Re: Traffic Noise Response Letter
289 Carling Avenue, Ottawa
GWE File No.: 19-048 – Response Letter

This letter describes how we have addressed comments prepared by the City of Ottawa in their memo dated October 4, 2019 pertaining to the traffic noise assessment performed for the proposed residential-use development located at 289 Carling Avenue in Ottawa, Ontario. Below is a summary of how each of the comments relating to the noise study have been addressed. The number sequence below is in reference to each of the numbered comments continued in the memo.

Drawing Title:
SITE GRADING AND DRAINAGE PLAN

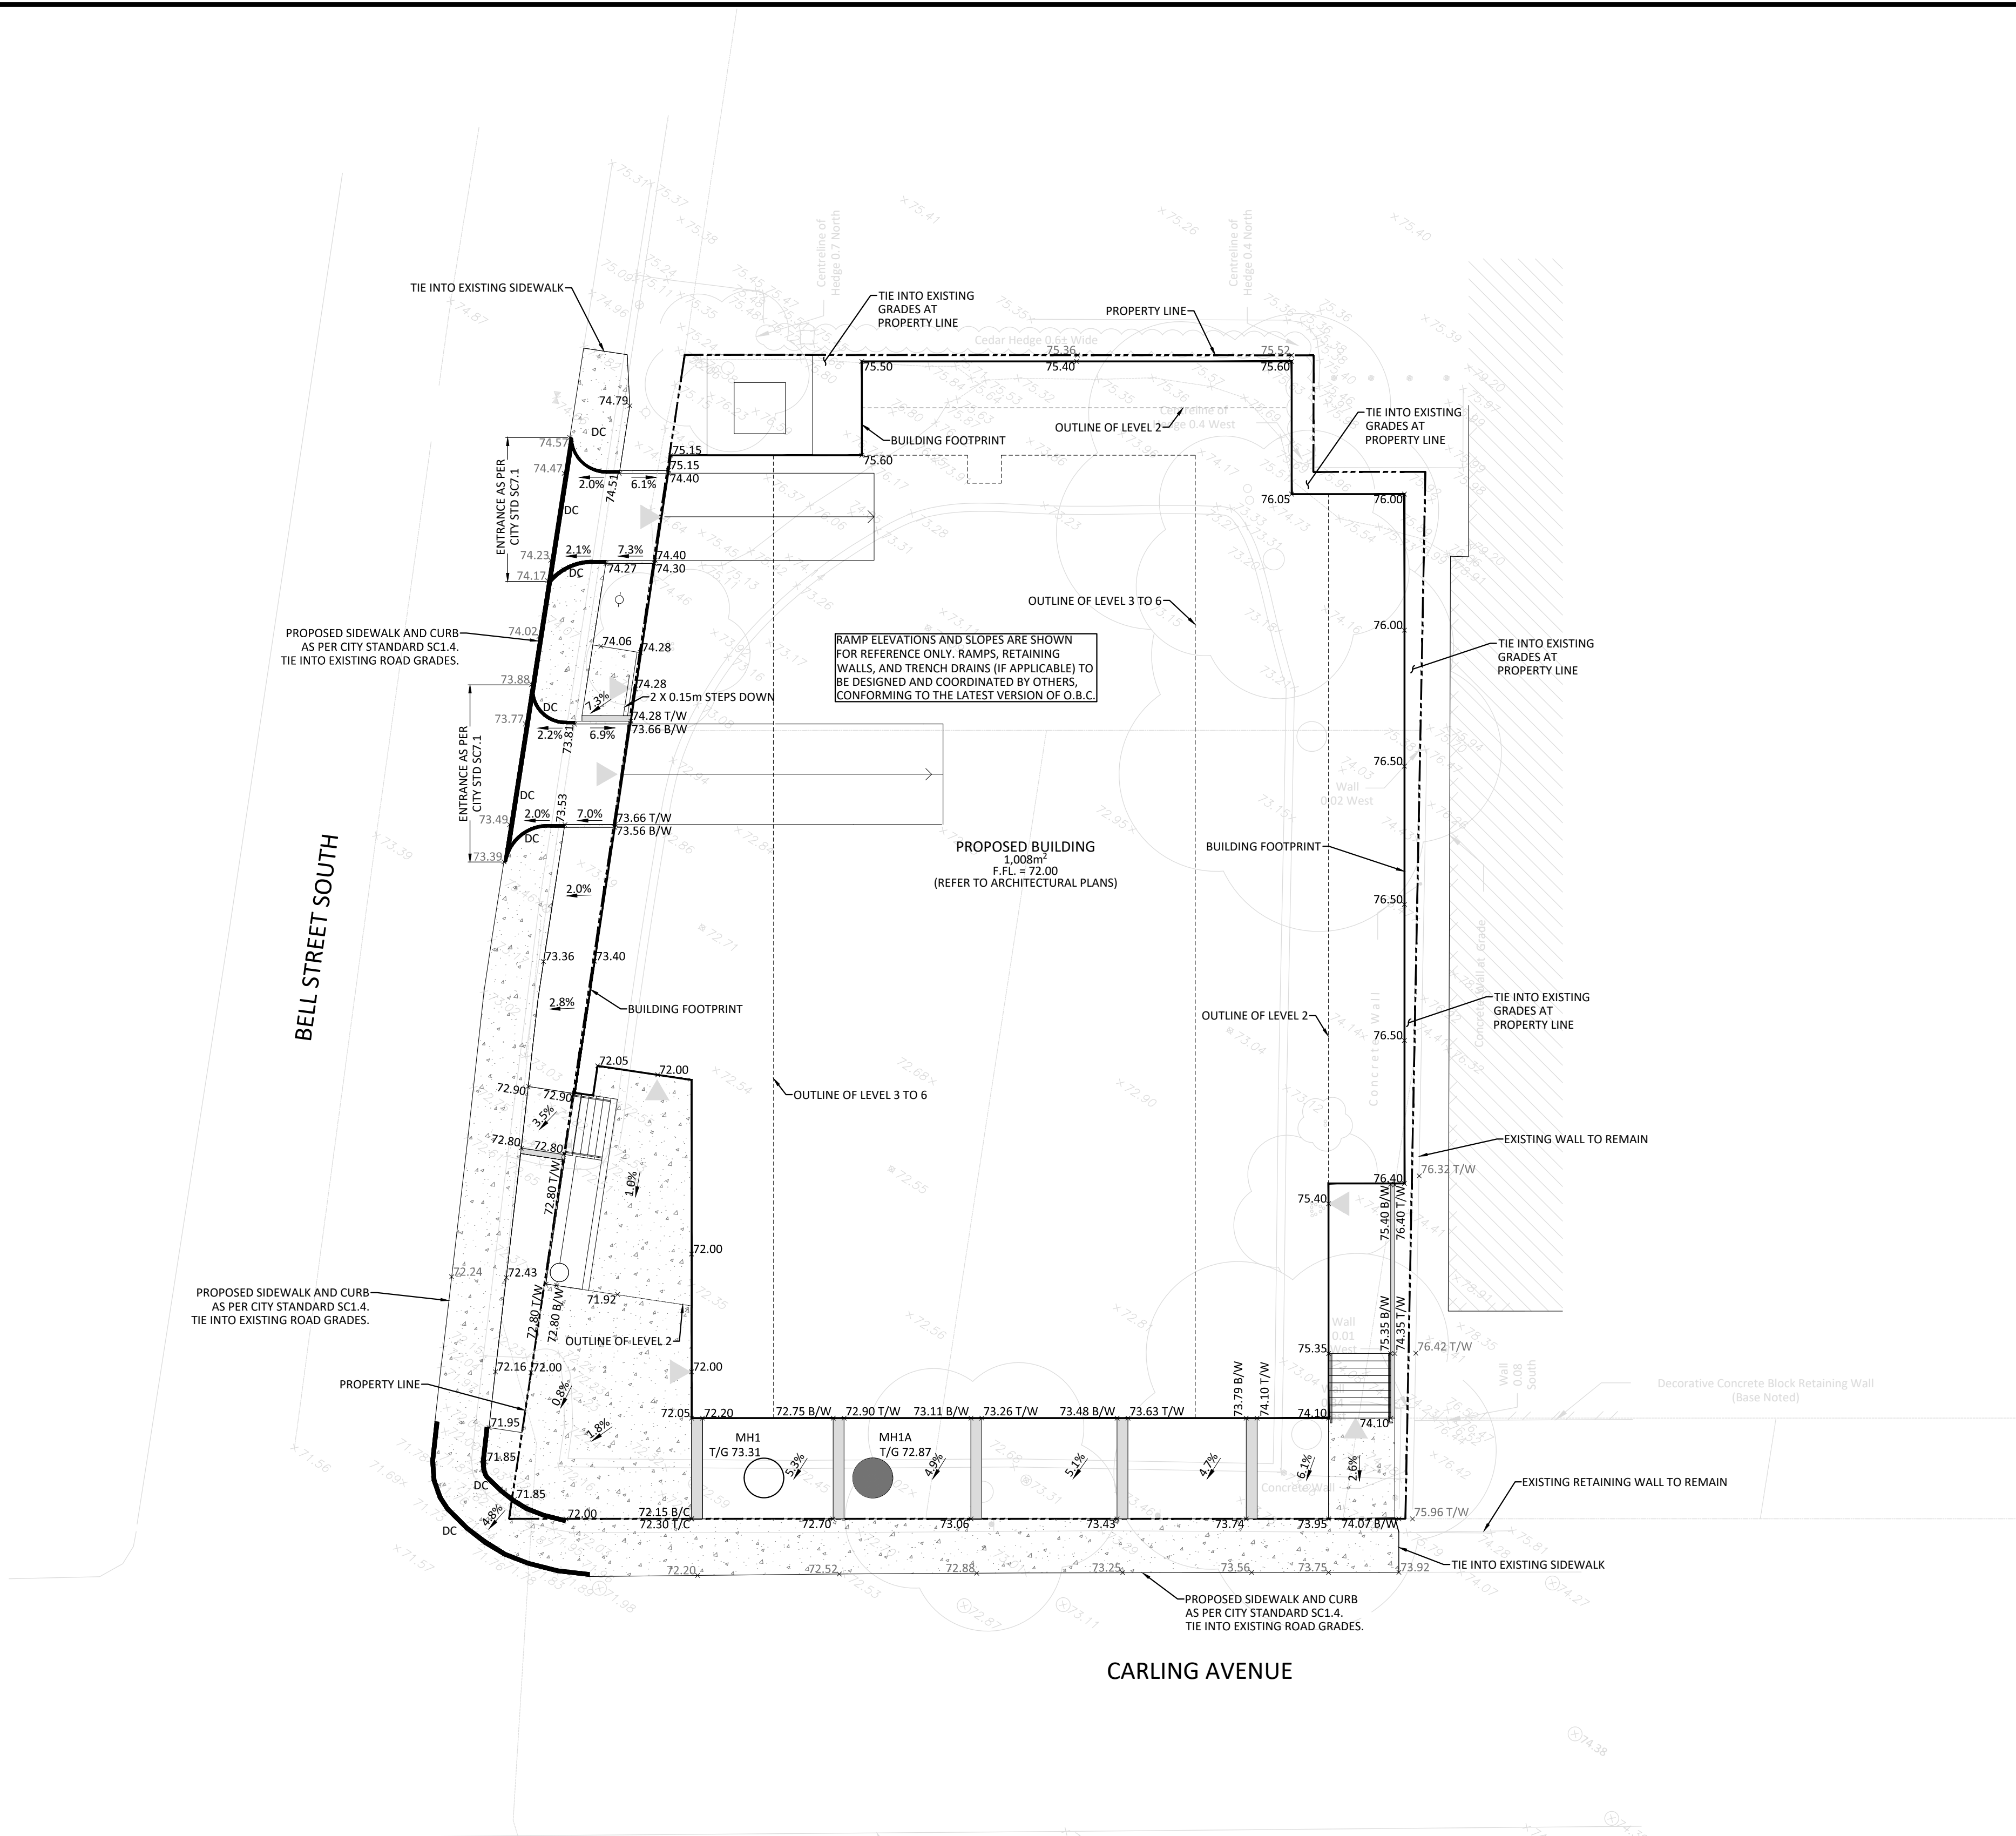
4. A copy of the site plan, elevation drawings and grading plan are to be included in the appendix as supporting documentation.

GWE Response: A copy of the site plan, elevation and grading plan drawings have been attached to this response letter. These documents are circulated at the time of submission and are made available on the City of Ottawa's development application website. Therefore, including them in our report is redundant.
